Harnett County
420 McKinney Pkwy
LILLINGTON, NC 27546
Phone:
Fax:

SUBJECT: BRES2109-0023
BUILDING RESIDENTIAL

Here are the results of all Inspections located at **685 WEST RD:**

Foundation Plan

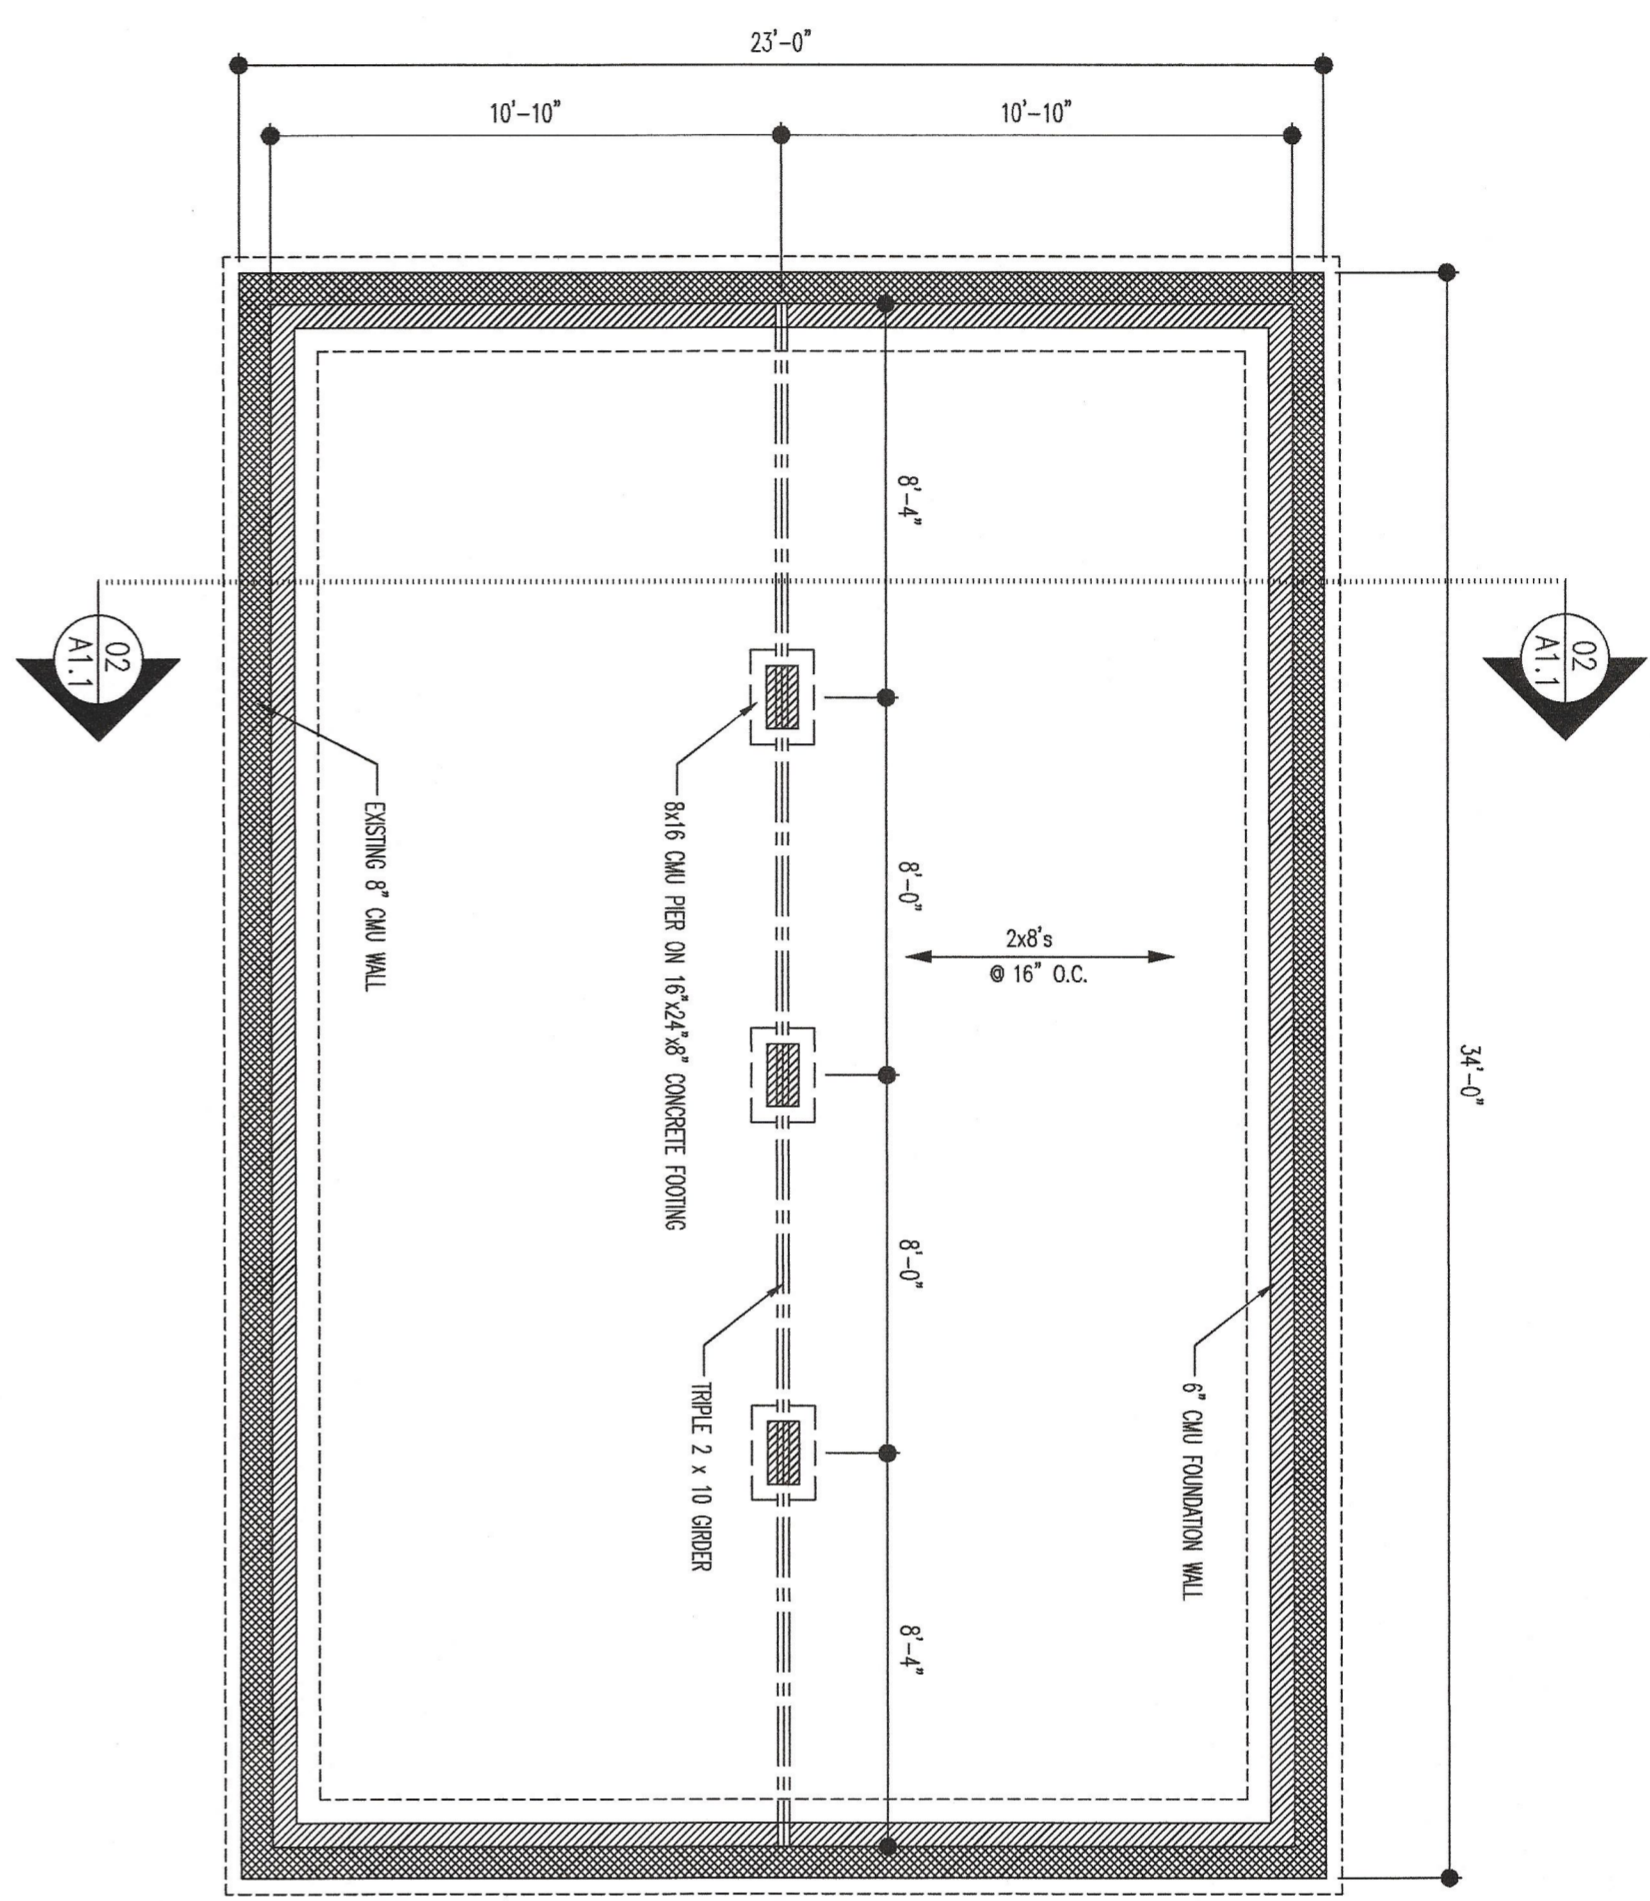
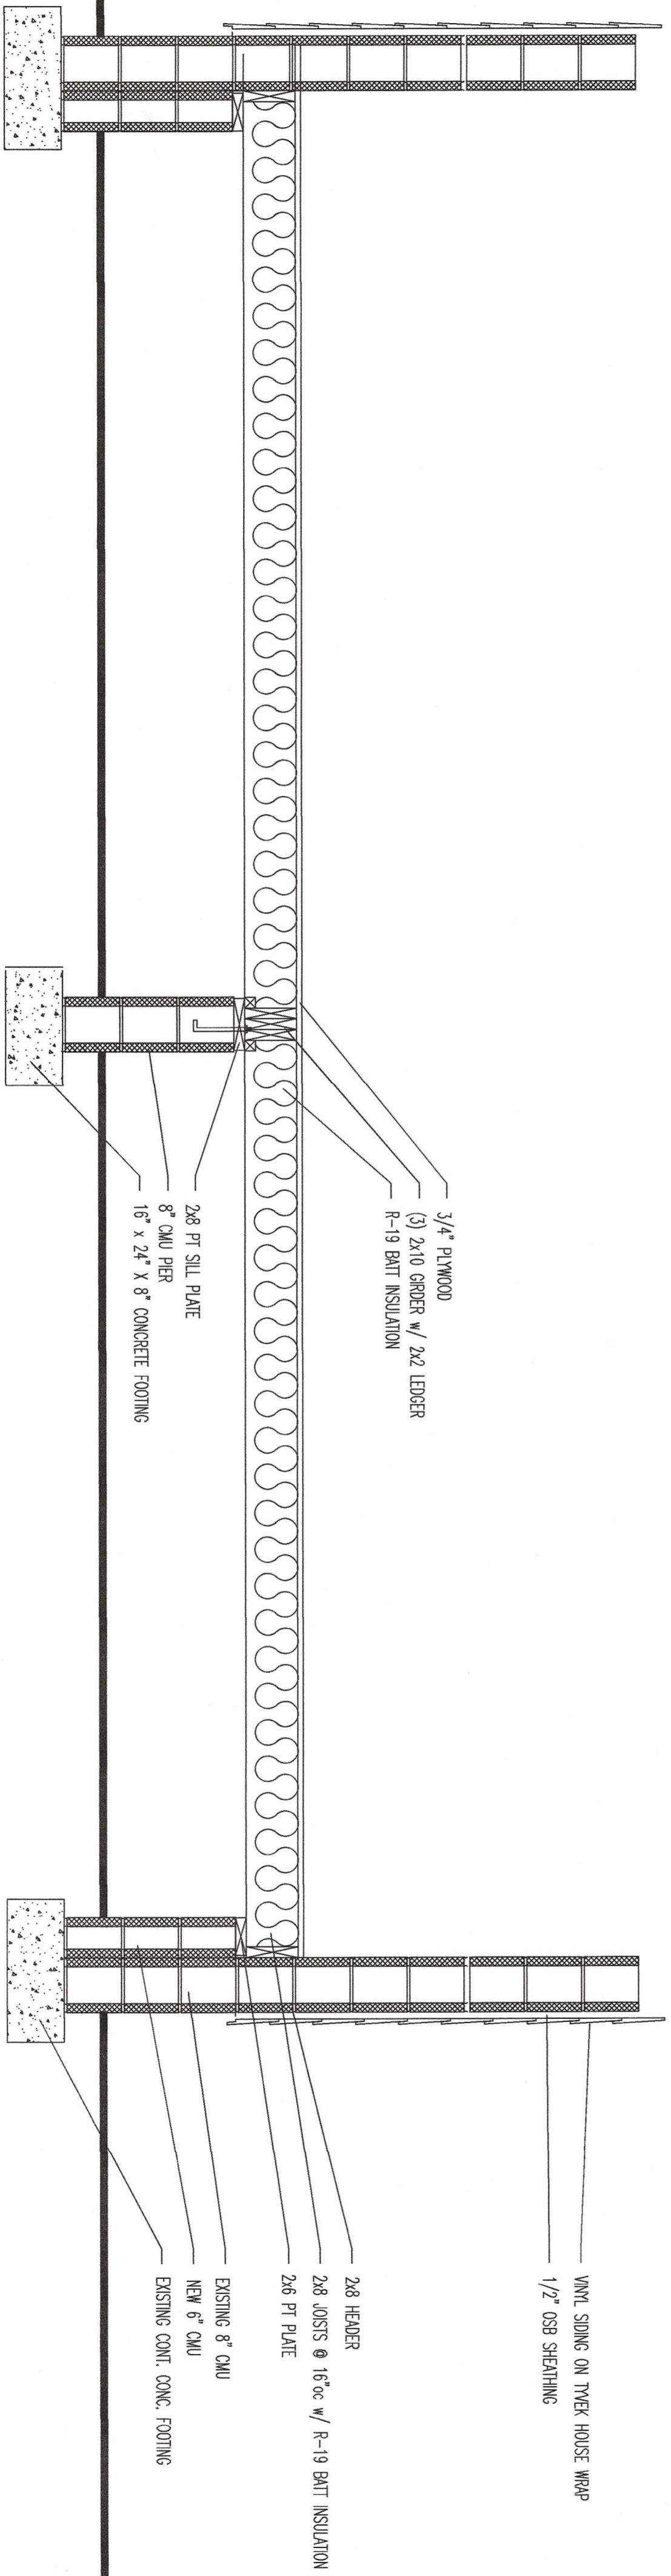
Foundation inspection never scheduled, provide engineering letter. Provide structural engineering letter on existing block wall. Replace broken pier blocks. Girder splices must occur over piers. Floor system must be treated or remove soils to 18 inch minimum below joists. Need 18x24 crawl access. Need foundation vents within 3 foot of corners. Replace hanger nails with 3.5 16d, or provide engineering. Anchor bolts missing in sill.

lock box code 6253
Provide engineering letter on foundation.
